From: Plant, Tom - Communities <Tom.Plant@Oxfordshire.gov.uk>
Sent: 24 June 2021 13:09
To: Bob Neville
Cc: Transport CDC Minor; Planning; Cllr George Reynolds
Subject: 21/01504/F - Swalcliffe Park Equestrian Park Lane Swalcliffe OX15 5EX

Planning application:	21/01504/F
Location:	Swalcliffe Park Equestrian Park Lane Swalcliffe OX15 5EX
Description:	Change of use from vets building to storage building with small office
Type:	Full Development
Case Officer:	Bob Neville

Drawn by SR	Date	Drawing Scale 1:500 @ A3
	Drawing Number 2215 - P2	Revision

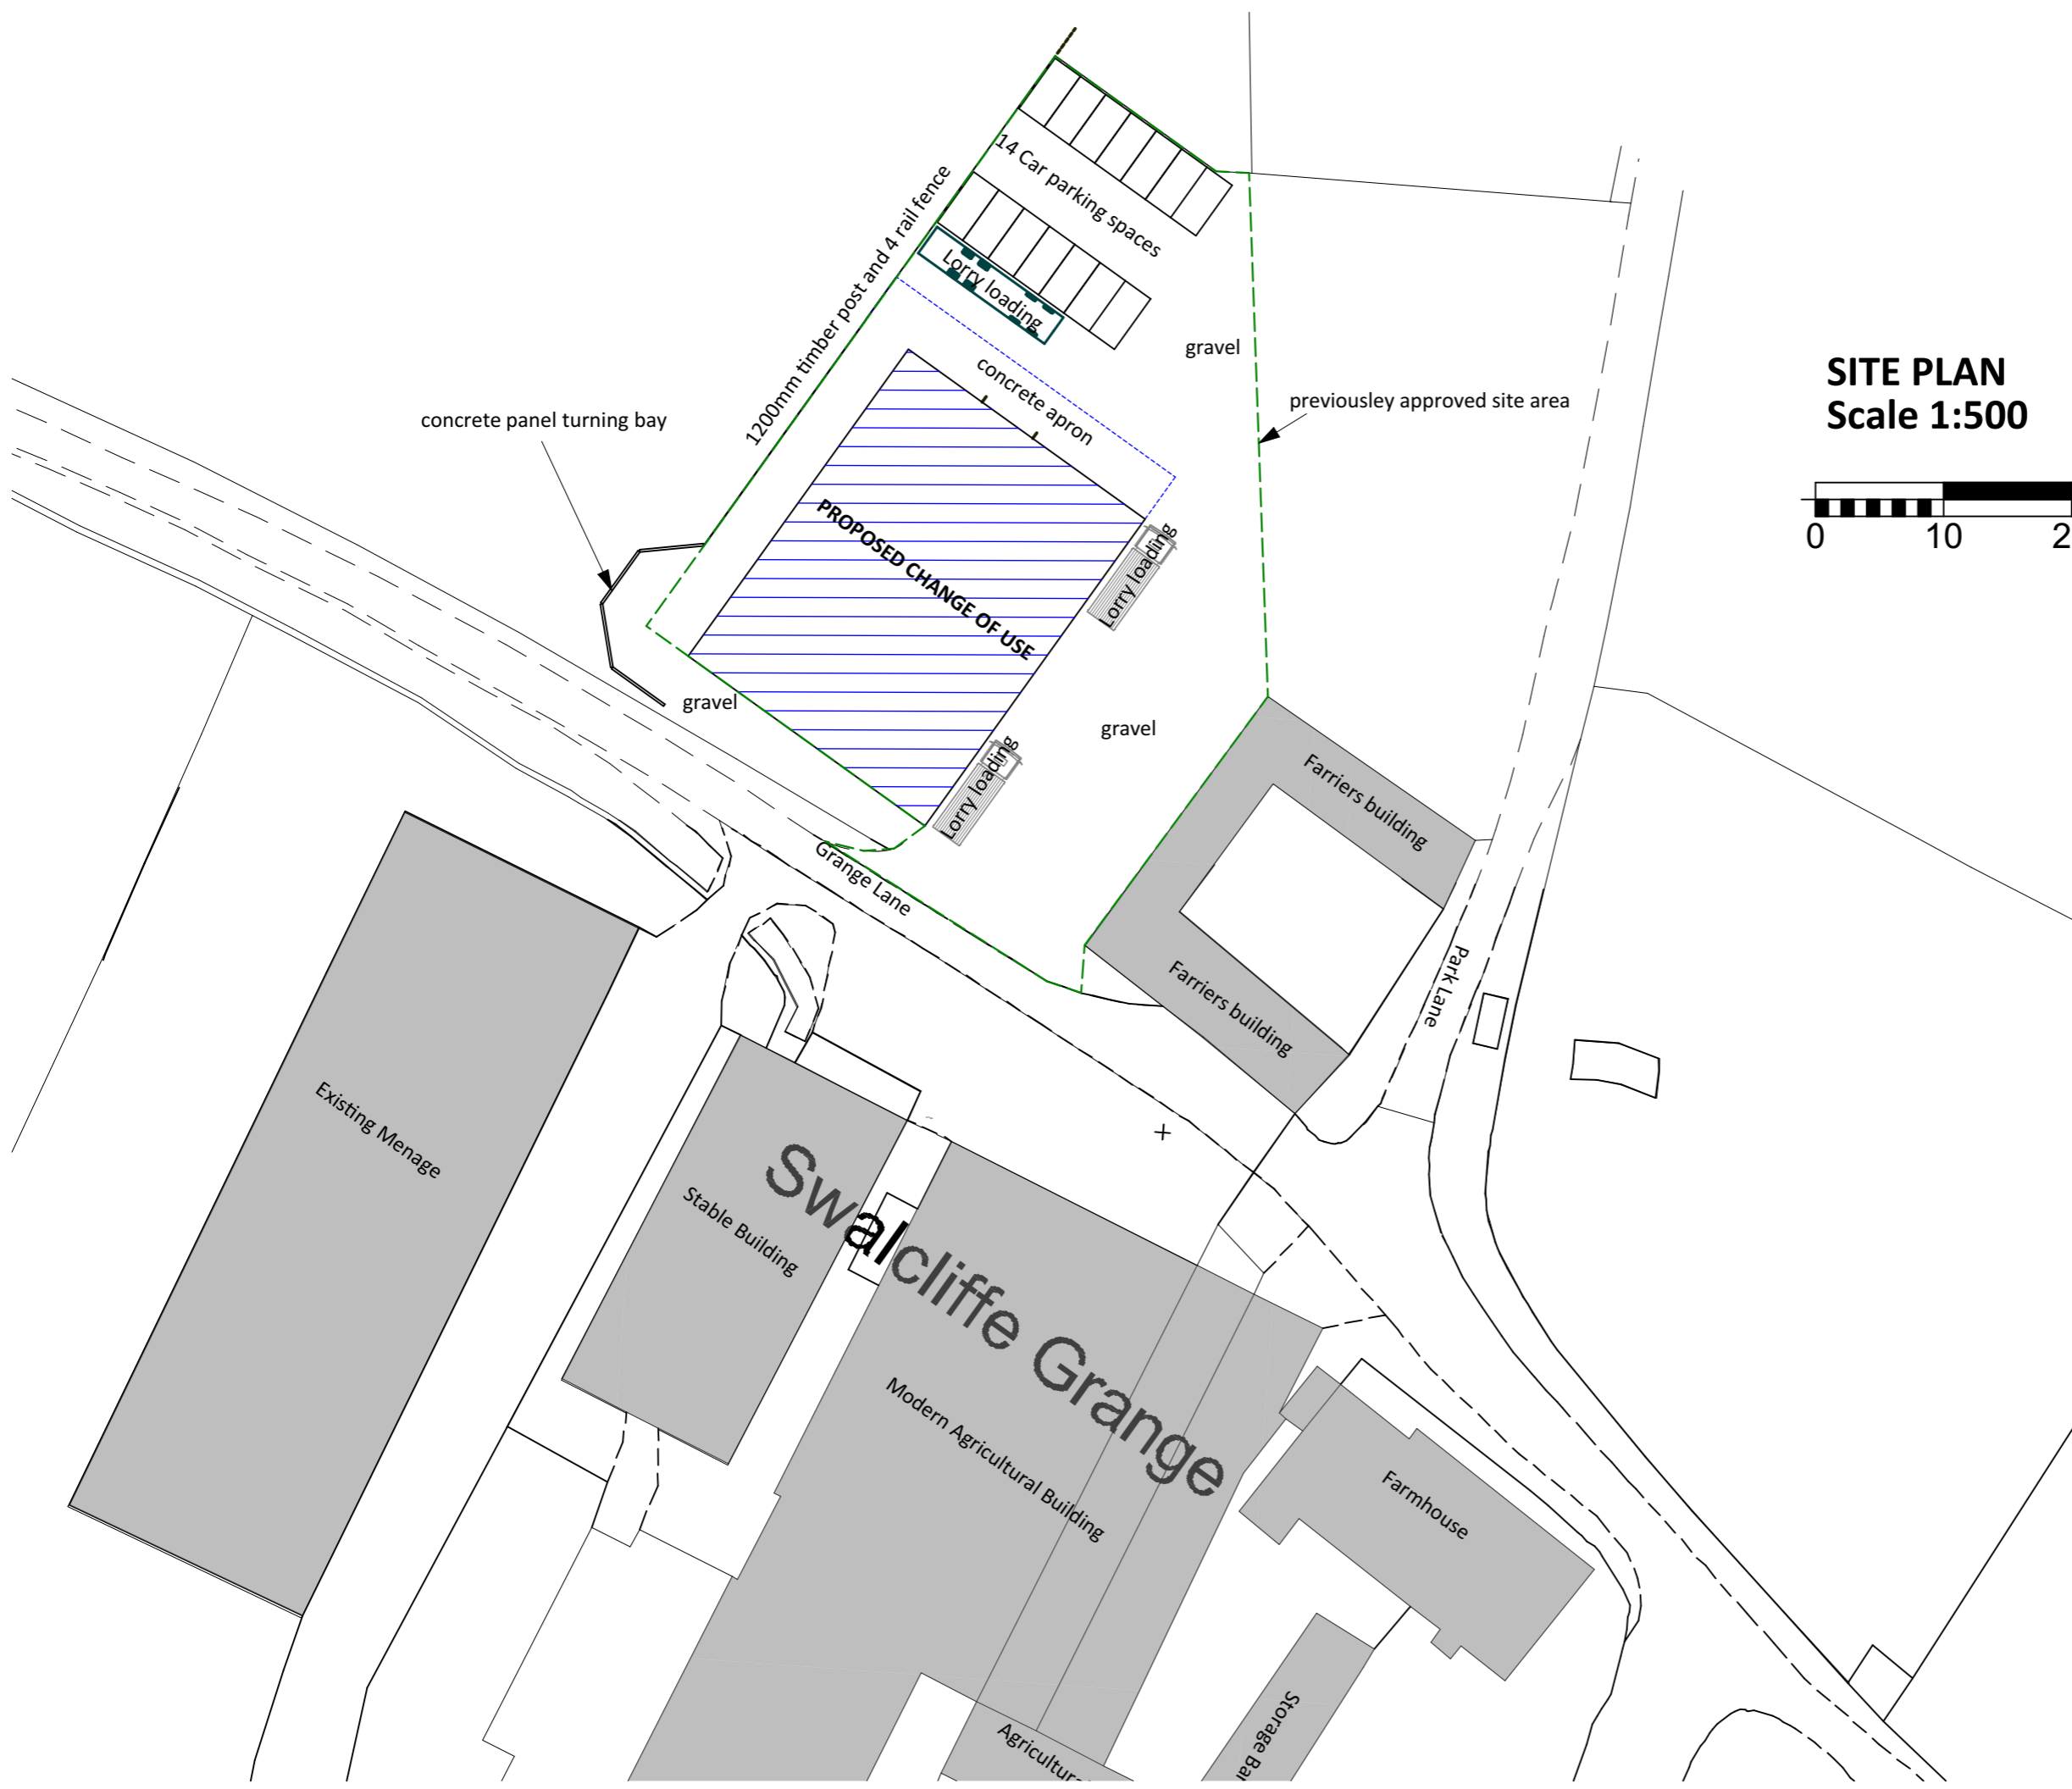
Prior to the first use/occupation of the development hereby approved, the parking and manoeuvring areas shall be provided in accordance with the plan approved Drawing No. 2215-P2 and shall be constructed from porous materials or provision shall be made to direct run-off water from the hard surface to a permeable or porous area or surface within the curtilage of the site. Thereafter, the parking and manoeuvring areas shall be retained in accordance with this condition and shall be unobstructed except for the parking and manoeuvring of vehicles at all times. Reason - In the interests of highway safety and flood prevention and to comply with Policies ESD7 and ESD15 of the Cherwell Local Plan 2011-2031 Part 1 and Government guidance contained within the National Planning Policy Framework.
